HERITAGE IMPACT STATEMENT PROPOSED DESIGN MODIFICATIONS - EDUCATION BUILDING 35-39 BRIDGE STREET, SYDNEY S4.55 APPLICATION TO MODIFY SSD7484

This concise Heritage Impact Statement has been prepared to assess the impact of the proposed design modifications to the approved proposal for the Department of Education Building (Education Building) located at 35-39 Bridge Street, Sydney. The proposed design modifications, the subject of the S4.55 Application to Modify SSD7484, are required because of:

TITLE
**PROPOSED ELEVATIONS - LANDS BUILDING
- NORTH, EDUCATION BUILDING - NORTH**

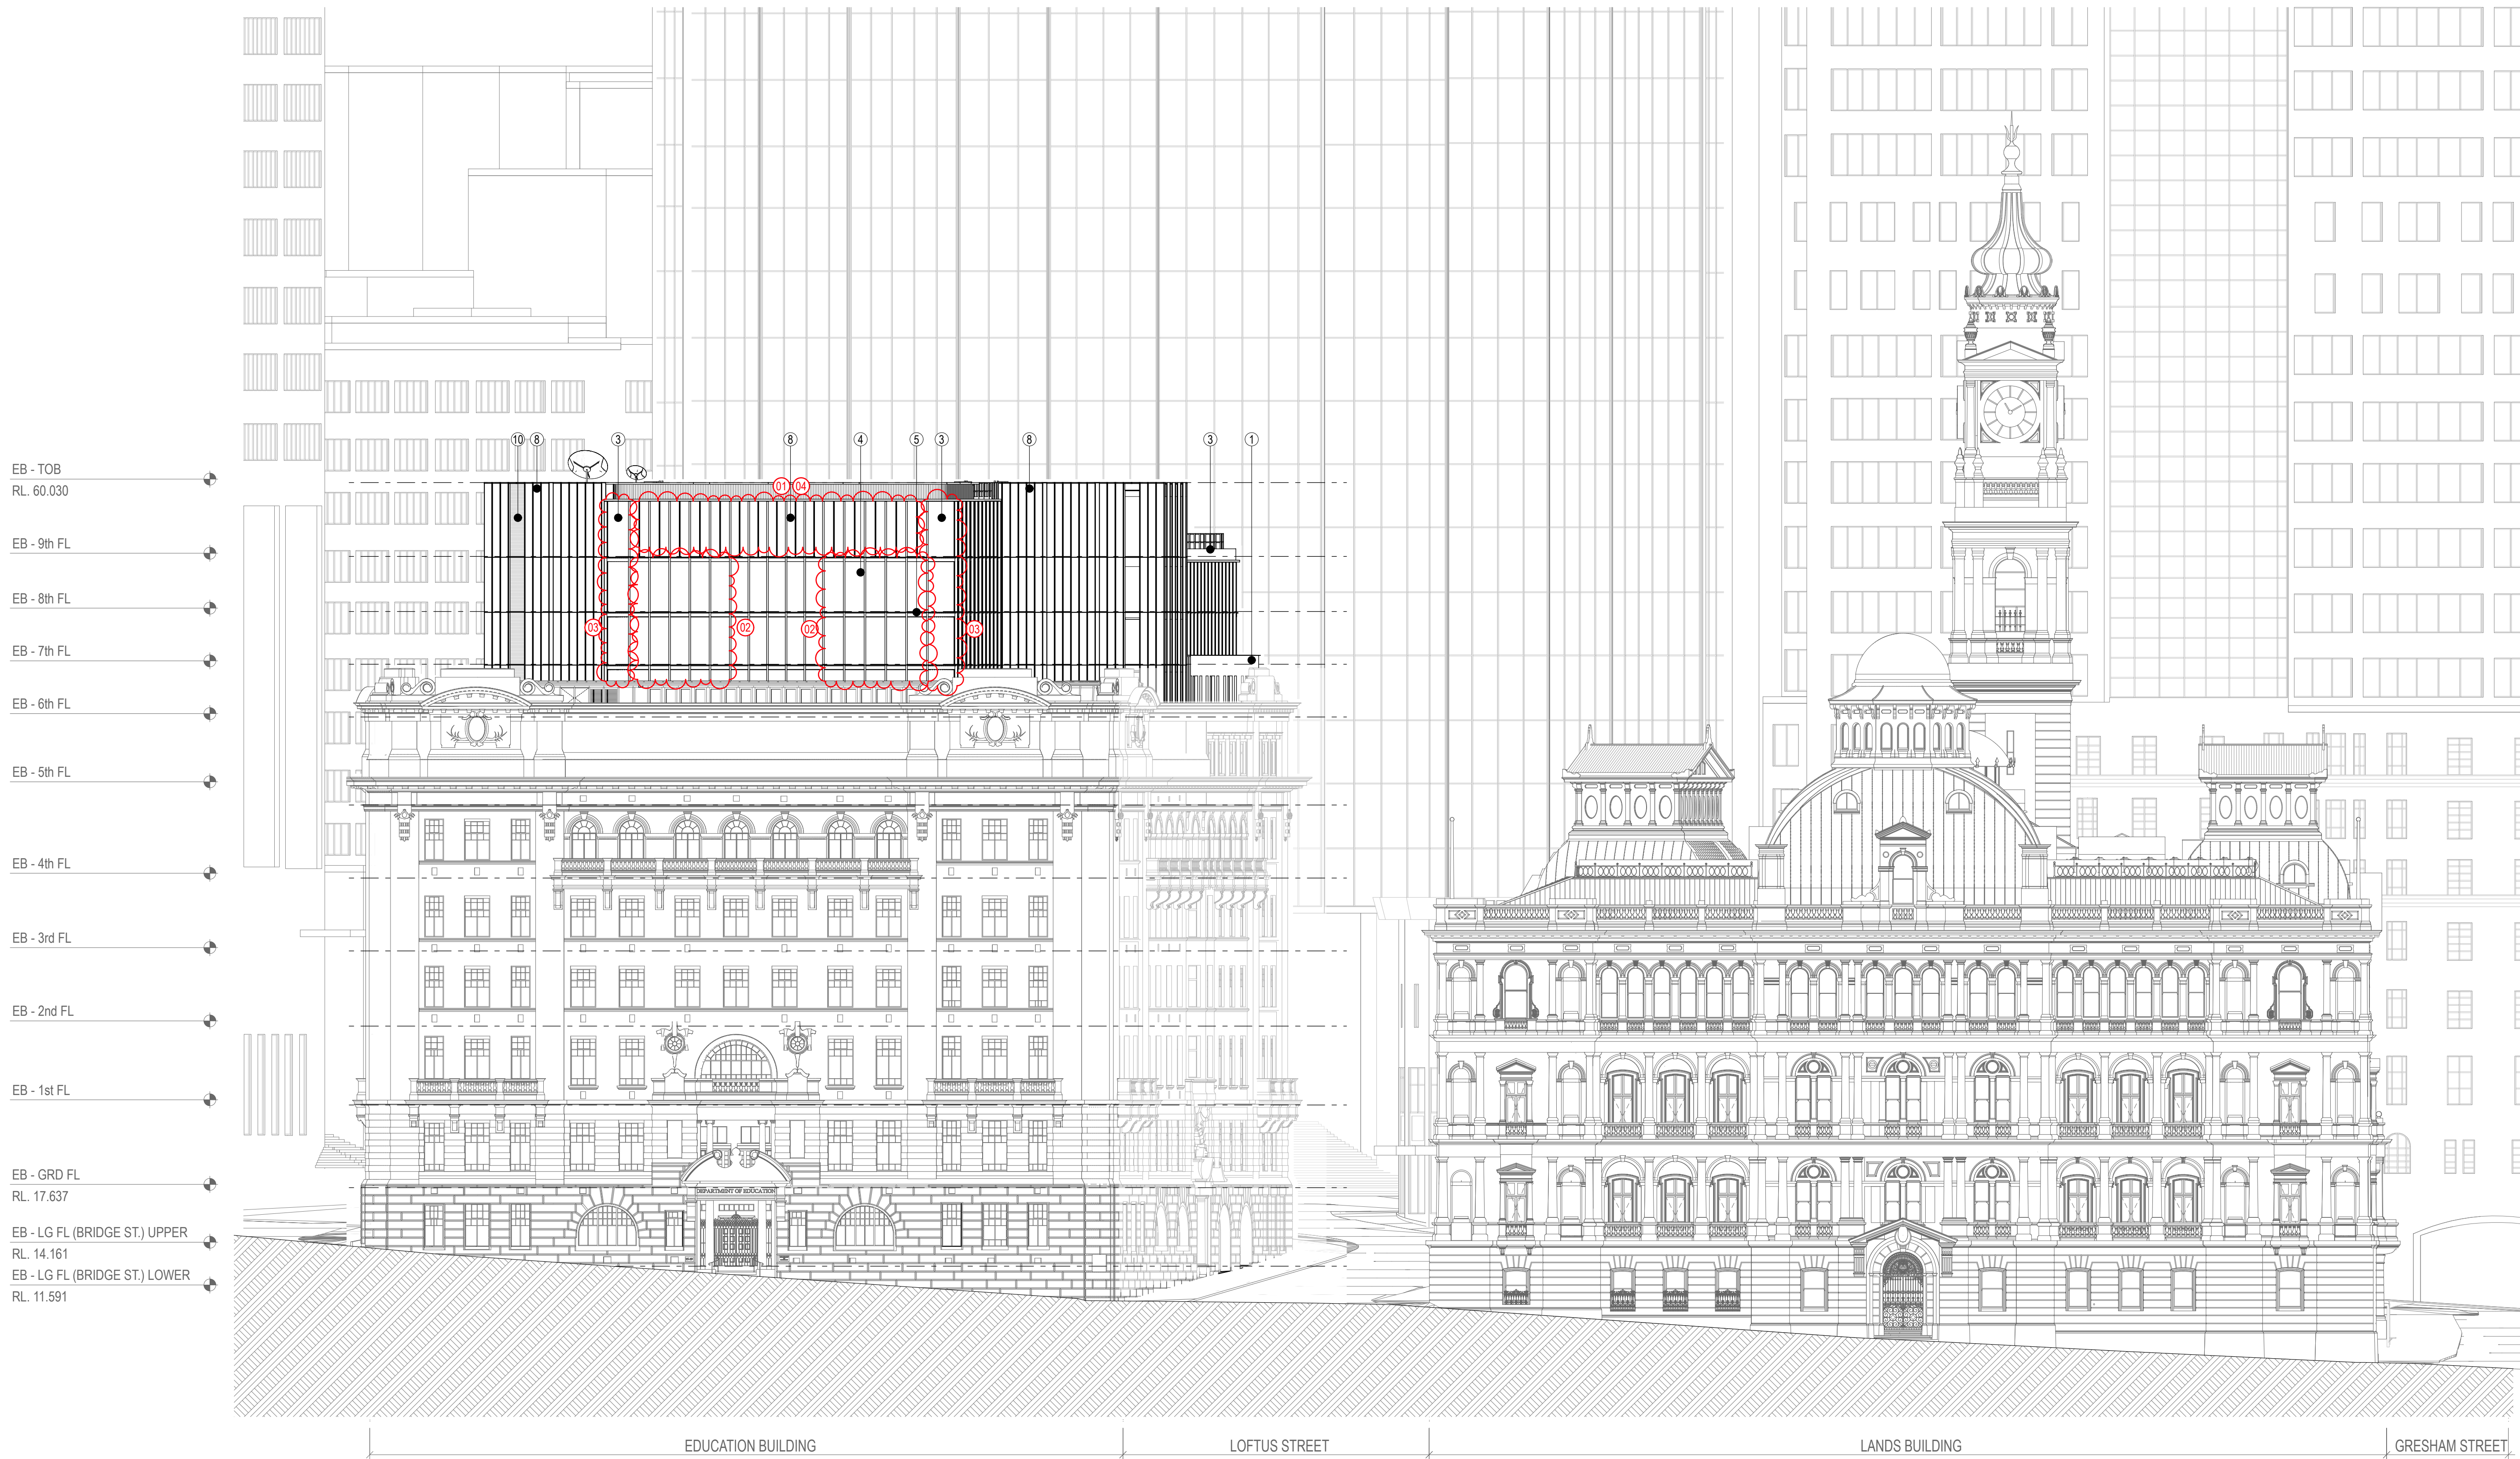
8. The Northern external face of the façade (FTE11) has changed from fluted perforated cladding to fluted solid cladding, as the plant room does not require the North side to be perforated for air flow.

TITLE
PROPOSED ELEVATIONS - EDUCATION BUILDING - EAST

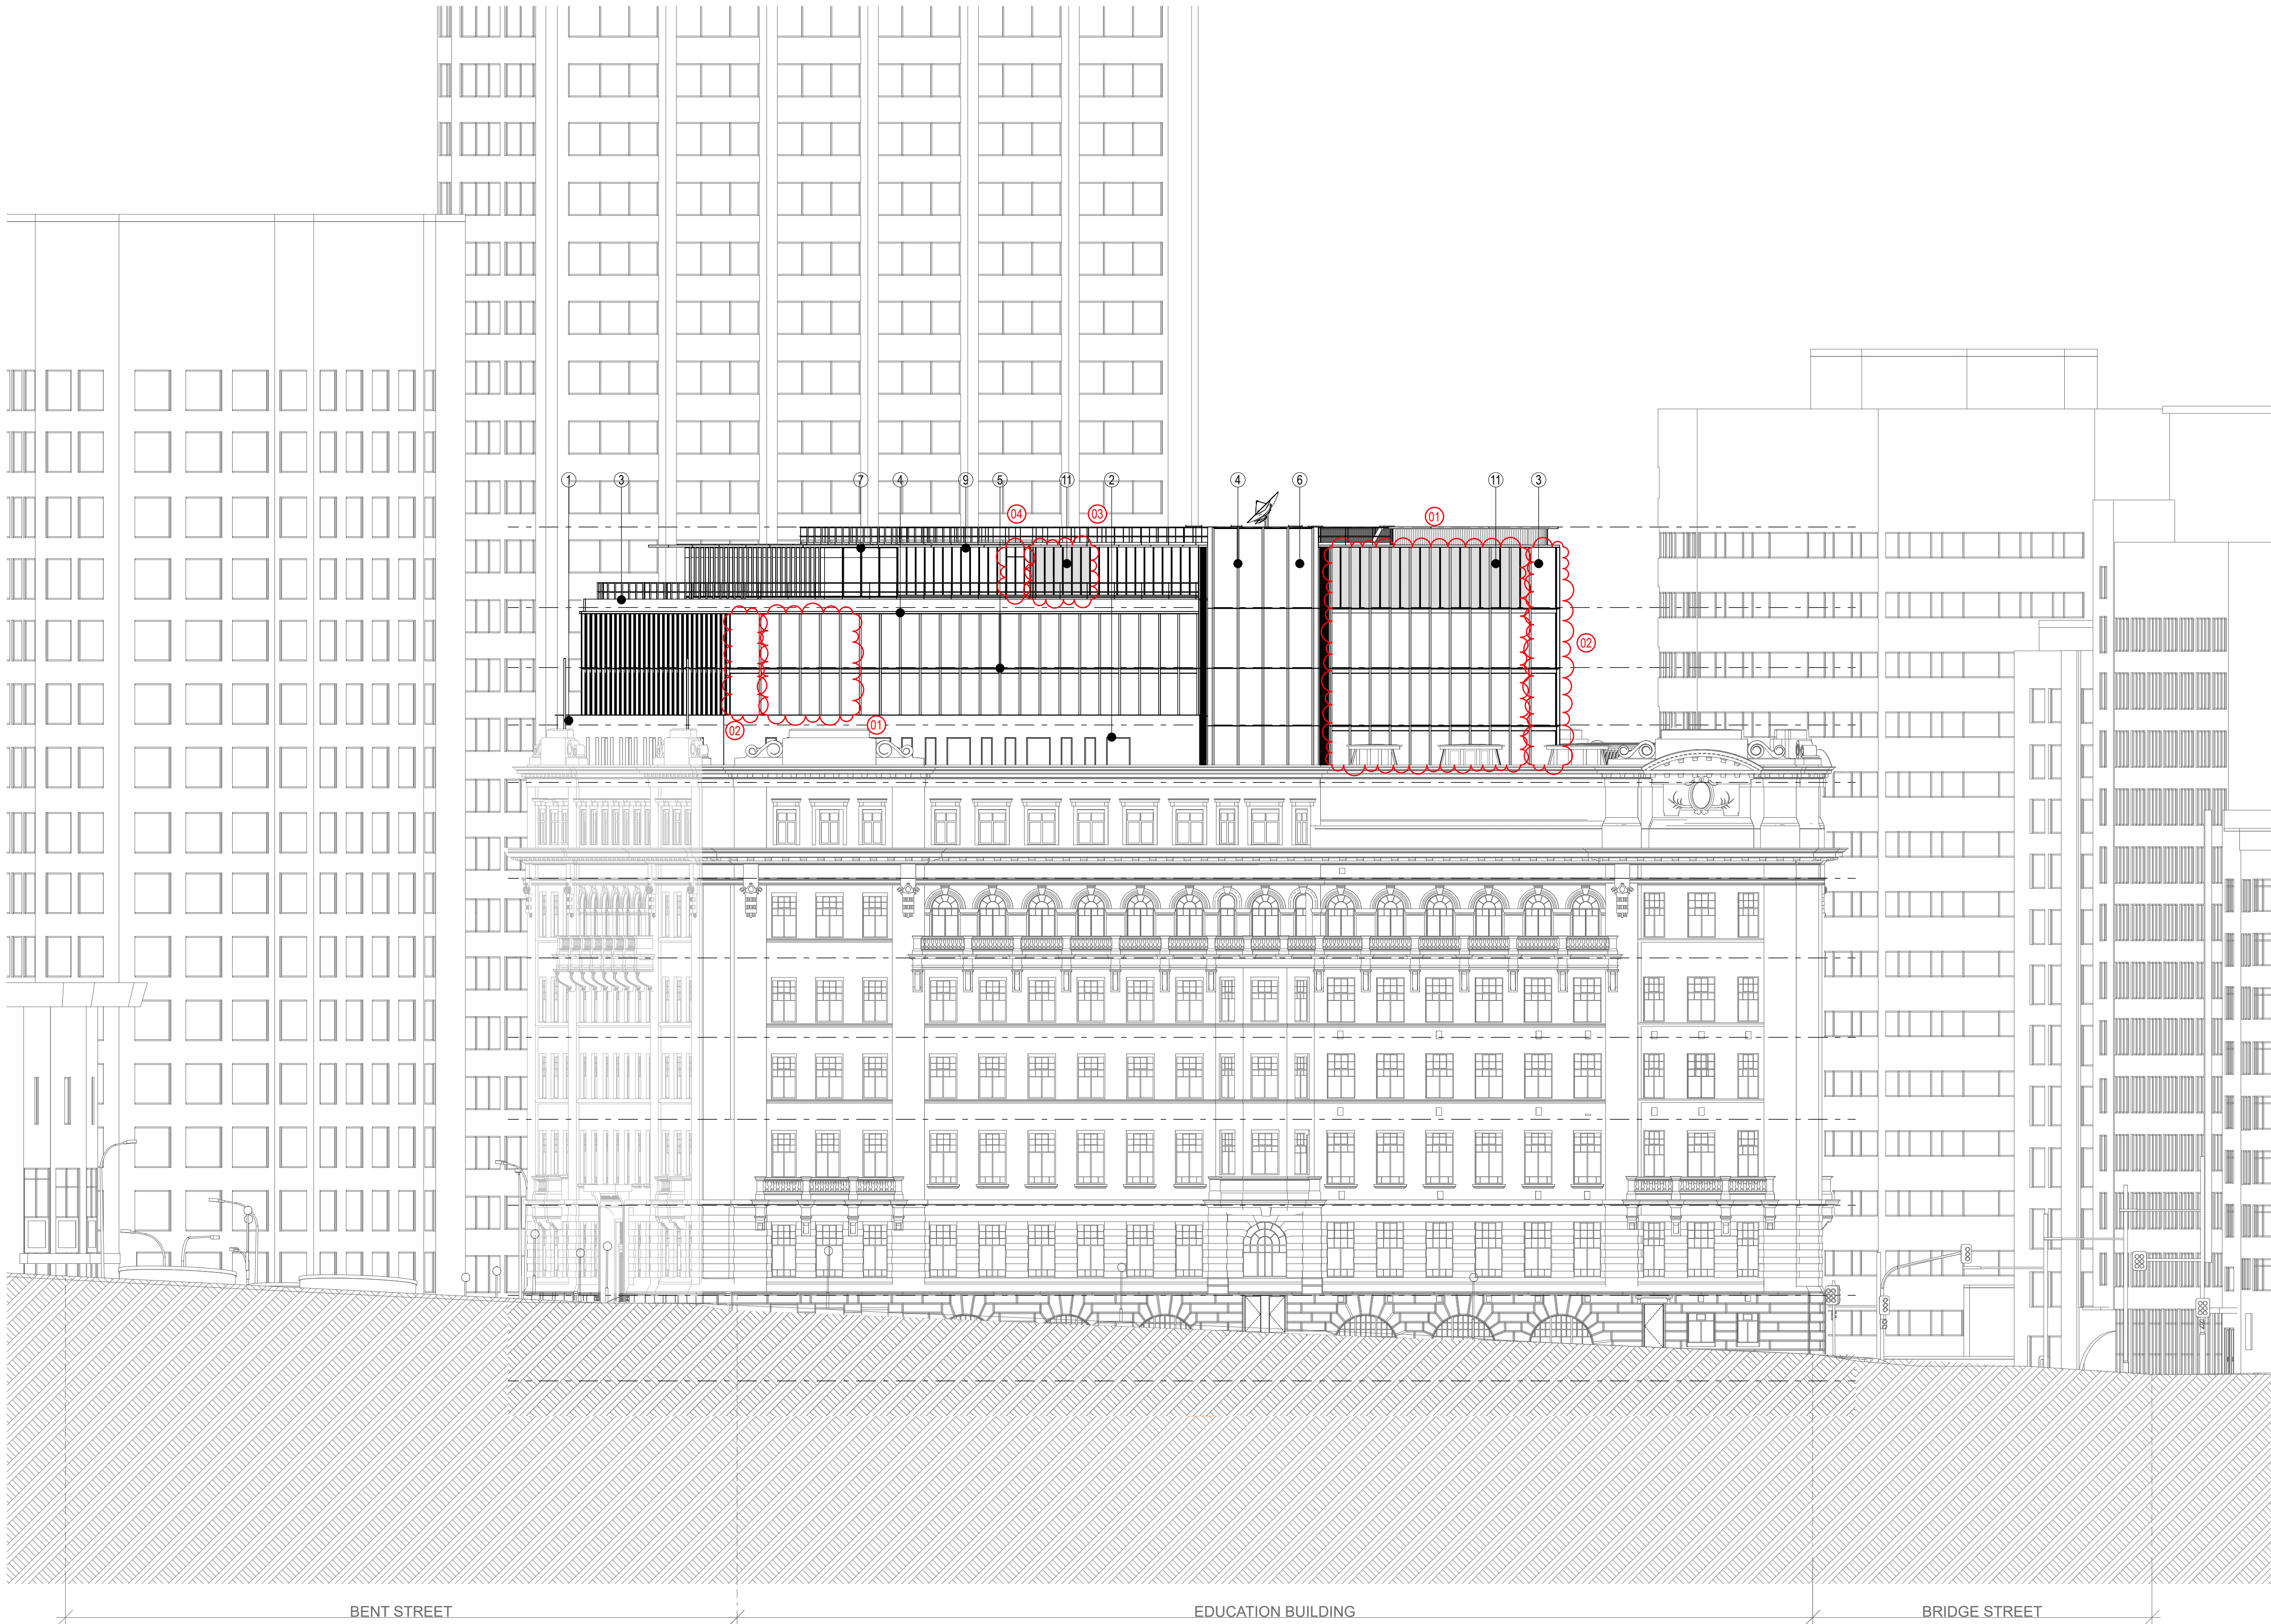
9. The plant room door on level 9 of the external Eastern elevation of the façade (FTE10) has been relocated a few panels South due to the internal room layout. The louvres have been relocated slightly North and are laid over 7 panels on their side. They are also covered by perforated fluted cladding to conceal the mechanical louvres and maintain the design intent.

TITLE
PROPOSED ELEVATIONS - EDUCATION BUILDING - WEST

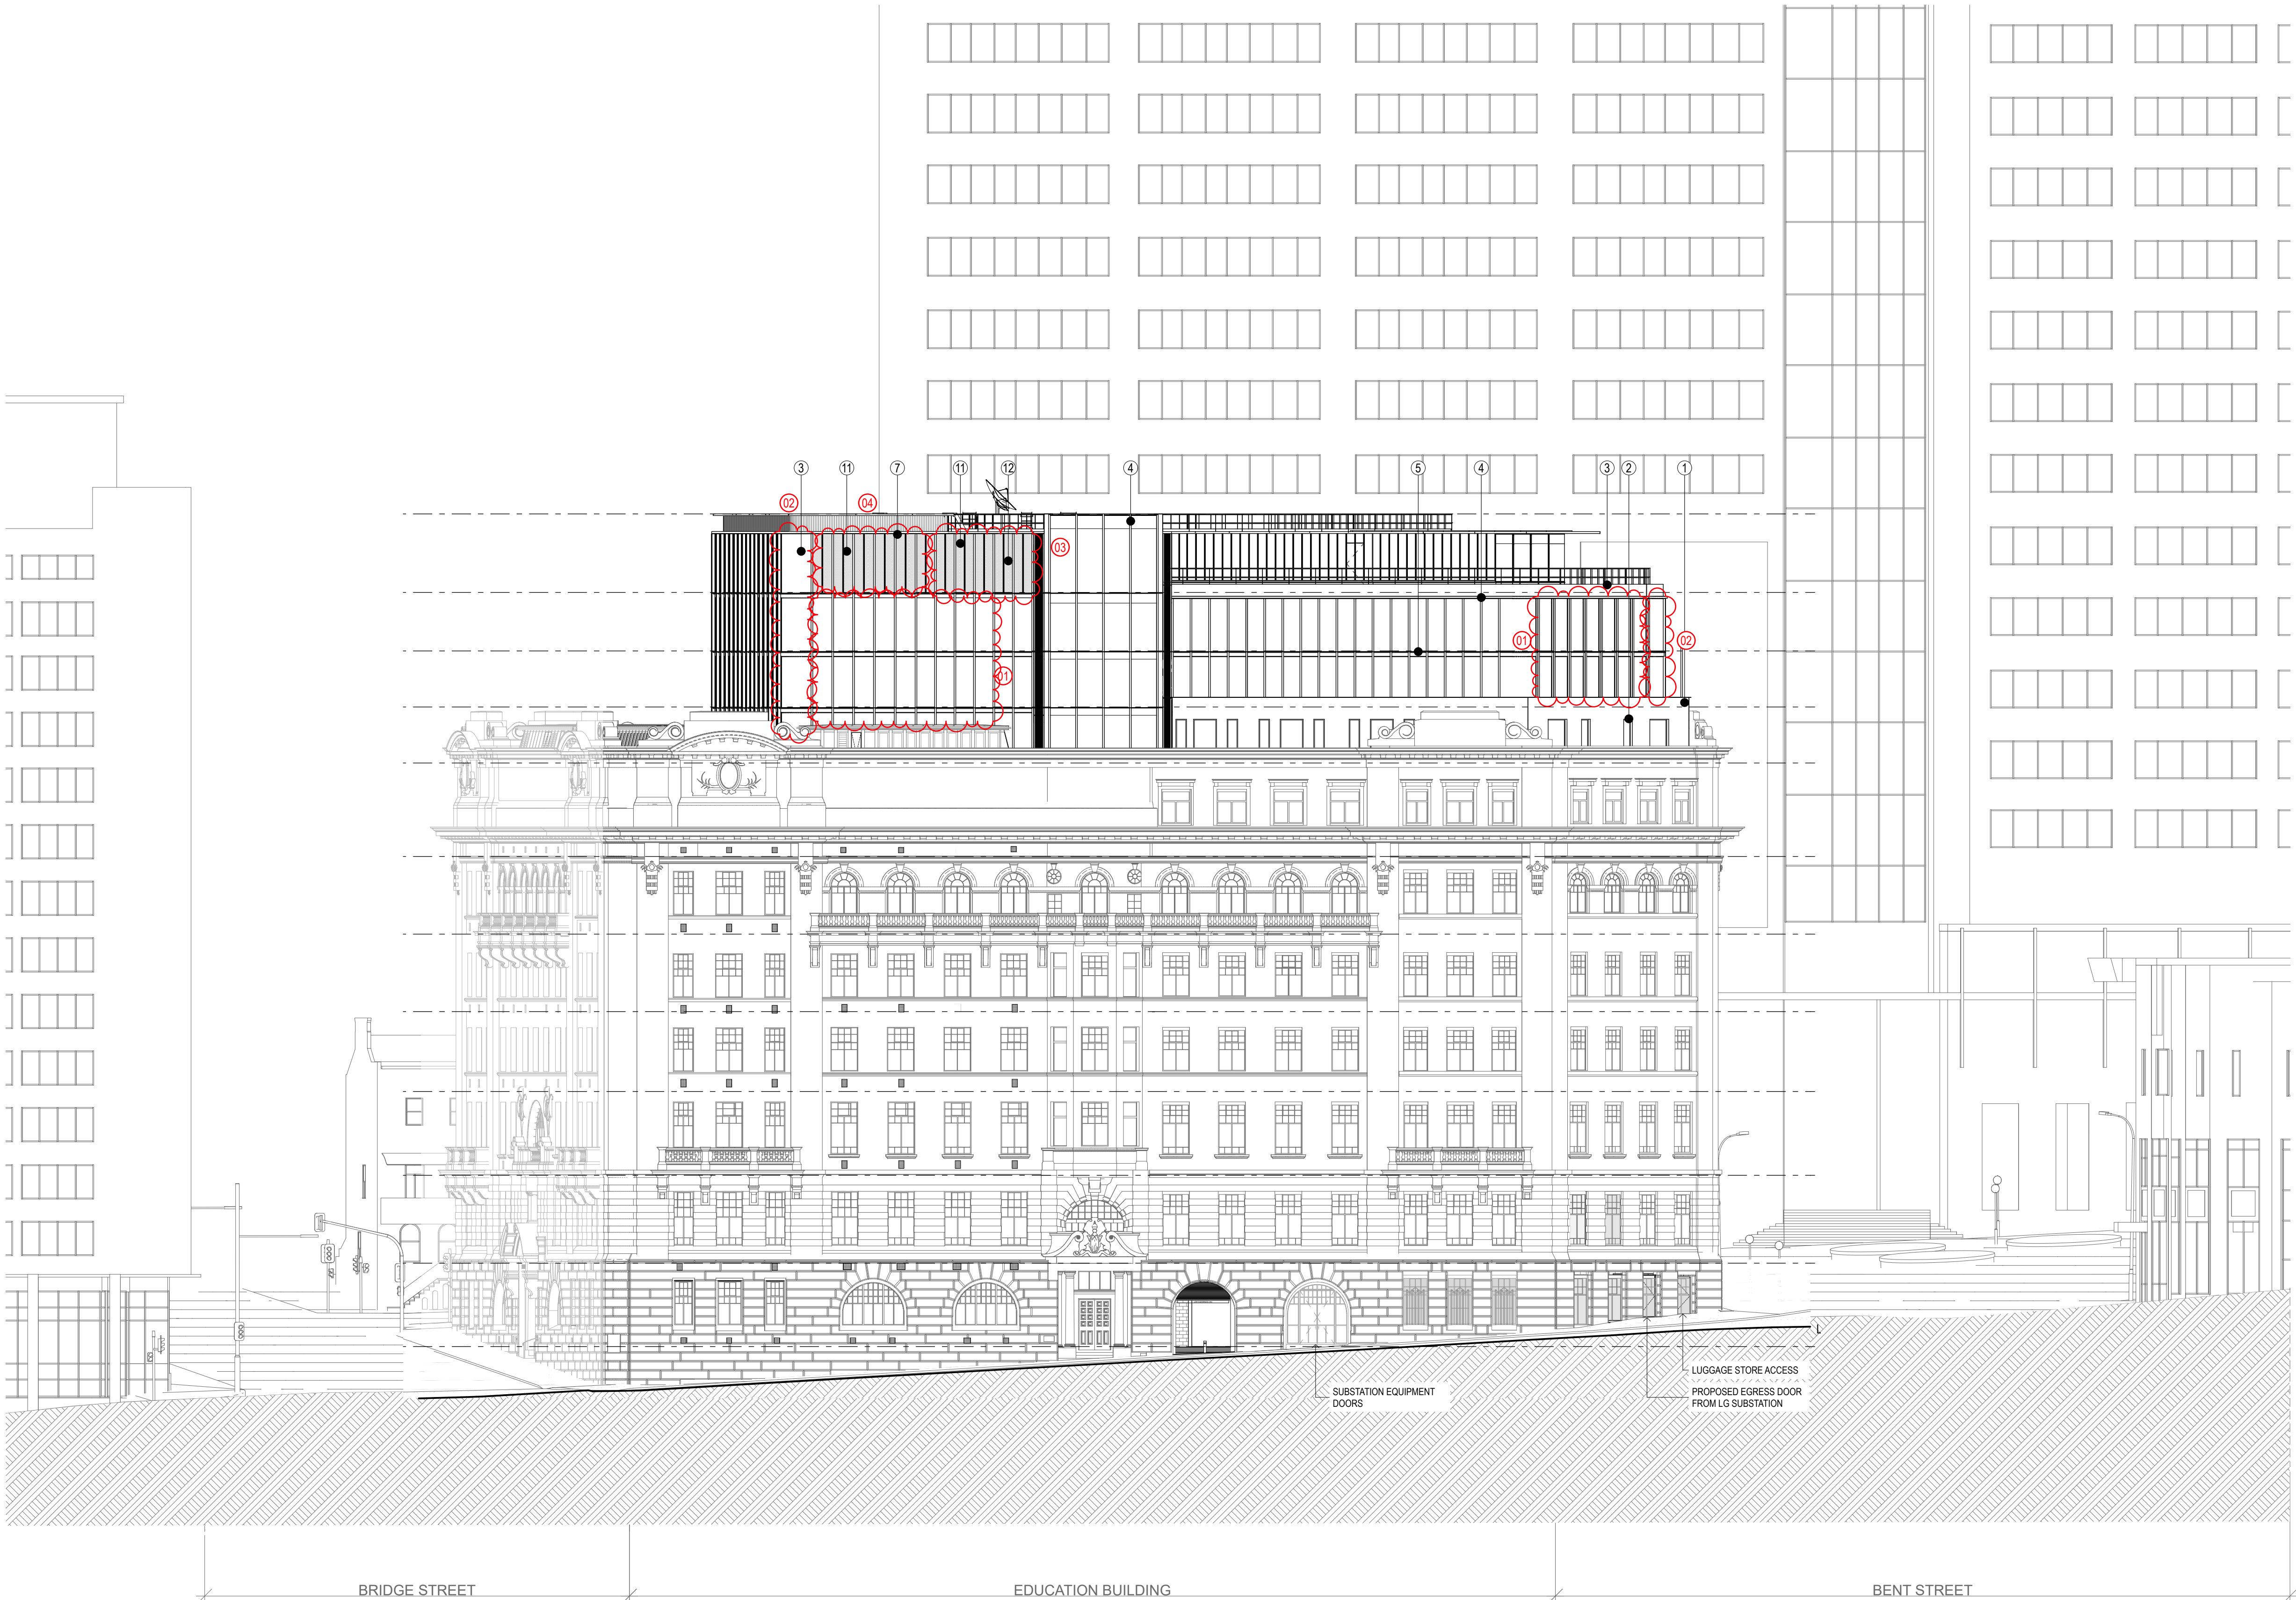
4. The louvres on level 9 Western elevation of the courtyard (FTE09) have been replaced by glass spandrels to maintain design intent in the courtyard. They have relocated to the external elevation of the external façade (FTE11 – Loftus Street face) and are covered by perforated fluted cladding to conceal the mechanical louvres.
